MMC traffic information & trip distribution - need for meeting Thursday?

Hi Nell – I have reviewed the trip assignment methodology contained in the April 18, 2018 email from Randy Dunton and I have the following comments:

Potential St. John Street Parking Garage Trip Assignment

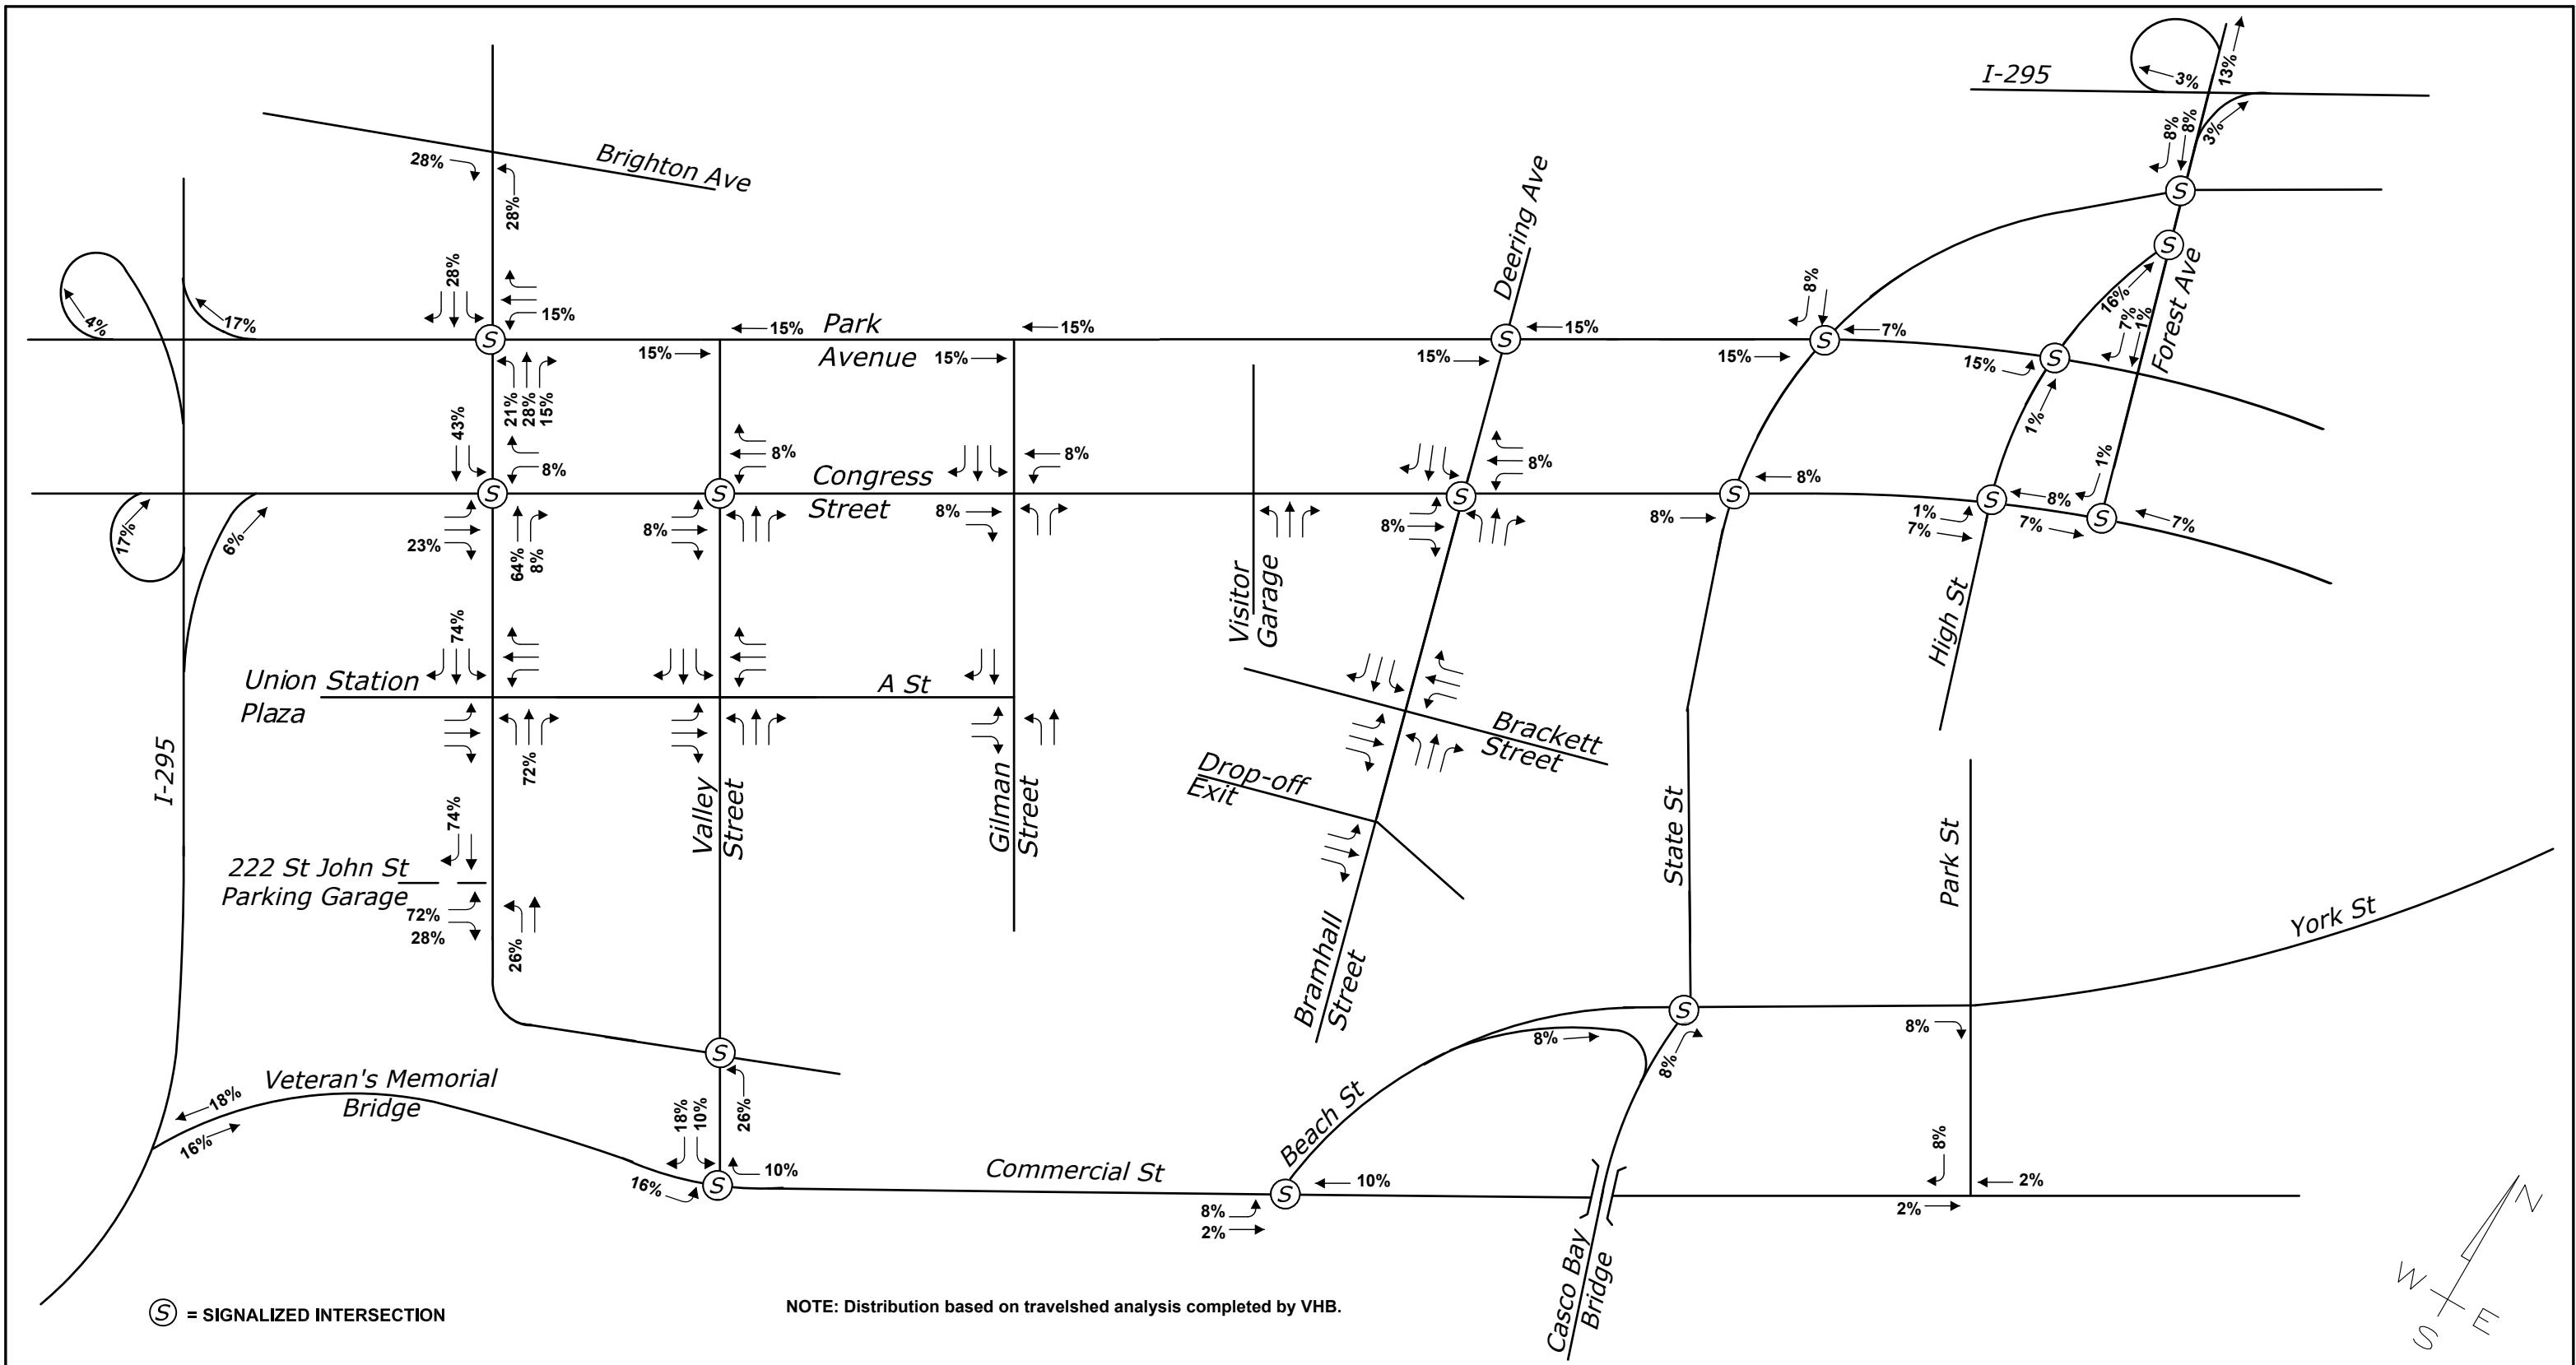
1. There are no MMC trips assigned to Outer Congress Street. Some MMC traffic should be assigned to Outer Congress Street, or documentation on why it is not expected should be provided.

2. The regional assignment of trips closely matches the VHB Employee Travelshed analysis with the following conclusions:
 - a. 17% of the trips are from I-95 (from the south). **[VHB estimated 17%]**

- b. 13% of South Portland area (Knightville/Cape Elizabeth) trips are split between 8% via Casco Bay Bridge and 5% via Exit 4 and VMB. **[VHB estimated 13%]**

- c. Of the I-295 NB trips from the south most will use VMB (16% in AM) with 6% (AM) using Congress Street (Exit 5). In the PM it is 18% using VMB and 4% using Exit 5.

- d. 20% of the trips will be destined to I-295 north of Forest Avenue with 17% using Park Avenue to the Exit 5 on-ramp and 3% using St. John Street/Park Avenue/High Street to Exit 6 on-ramp. **[VHB estimated 12% for I-295 north of Portland. It is unclear if trips are getting off Franklin or Washington – possibly to I-95NB].**

- e. 28% of the trips are assigned to Brighton Avenue. **[VHB estimated 25%].**
 - f. 13% of the trips are assigned to Route 302 north of I-295. These trips originate from Park Avenue. **[VHB estimated 13%]**

- g. 9% of the trips are assigned to the Peninsula with 2% via Commercial Street and 7% via Congress Street. **[VHB estimated 9%]**
3. GPCEI previously provided an Existing Employee Garage Trip Assignment estimate for the AM and Peak hours. This was based upon a traffic count at the existing garage and turning movement volumes at nearby intersections. The approximate outcome is noted below:

Based upon the above, I would suggest that the two sets of information be merged in the development of a final assignment. In general, the VHB regional travelshed methodology seems reasonable. What is not clear is how motorist will route to the travelshed areas, particularly in the vicinity of MMC. Some notable discrepancies:

- Congress Street inbound from the west approaching St. John – 23% vs. 46%
- Brighton Avenue – 28% vs. 17% in AM and 15% in PM
